**PROP Family Housing**  
Project Name/Description

RE: PROP 9-Unit Subdivision, Anderson Street  
ID #2002-0140, CBL #012-B-009

**TO: Kandi Talbot – Planner**  
**FROM: Jim Seymour – Development Review Coordinator, Sebago Technics, Inc.**  
**RE: PROP Family Housing – 113 Anderson Street**  
**DATE: July 2, 2002**

7 DUMPSTER ENCLOSURE DETAIL NOT TO SCALE

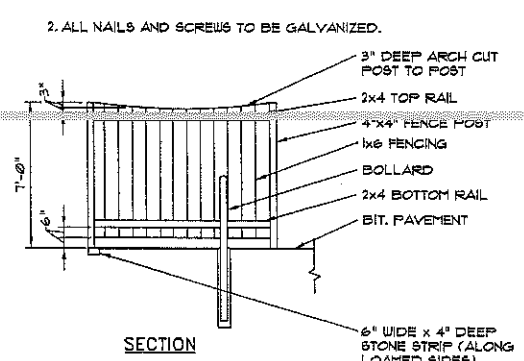
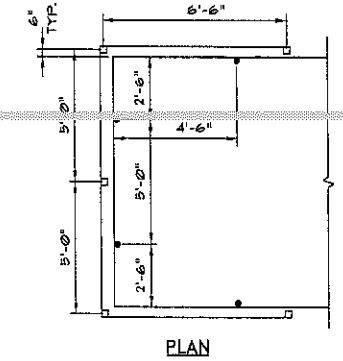
- C. Dumpster location/access by residents/waste hauler raises concern. It appears that residents are to access the dumpster from the north and the waste hauler from the south. Does a typical dumpster container facilitate this use/approach? Typically, a container is accessed from the same side by all users. The applicant may have to obtain an easement for access to the dumpster from Portland Housing Authority property since two different lots are being used. The may want to combine the dumpster location to require only one dumpster pick-up.

9 SHRUB PLANTING DETAIL NOT TO SCALE

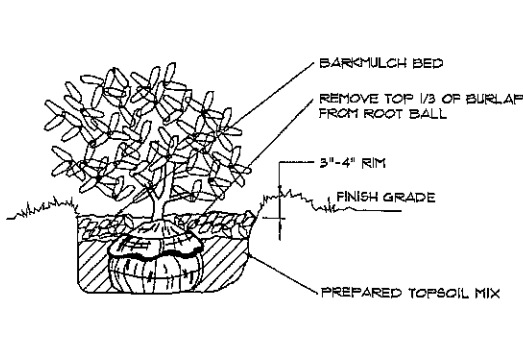
- A. Two planting details are included as items 8 and 9. Their proposed locations and species should be noted on the appropriate plan.
- B. Dumpster enclosure details are needed.
- C. Erosion control notes, seeding notes and details shall be placed on the plans so that the contractor will have them in the field.
- D. Appropriate BMP details shall be included on detail plan sheet.
